Residential Development Baldoyle GA2

Stage 1 Road Safety Audit

<b>Client:</b>	Lismore Homes Limited
<b>Project Title:</b>	Residential Development Baldoyle GA2
<b>Document Title:</b>	Stage 1 Road Safety Audit
<b>File Name:</b>	20211-BT-00-XX-RP-C-02001_Stage 1 Road Safety Audit.docx

1 | 1 : 200

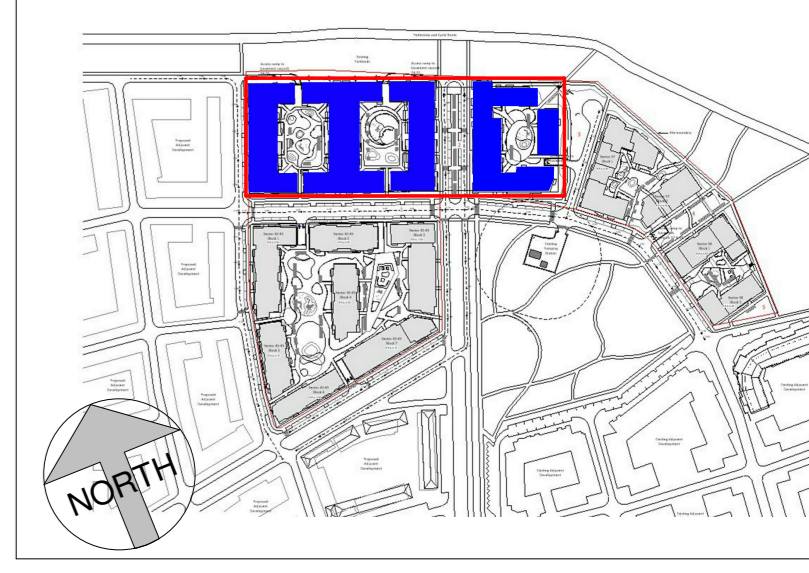
Some underground car park exits have restricted visibility to the footpath due to retaining walls and/or building corners. This could lead to vehicle/pedestrian collisions as exiting drivers might not see the crossing pedestrians in time to react.

Adequate intervisibility between drivers exiting underground car parks and crossing pedestrians should be provided.
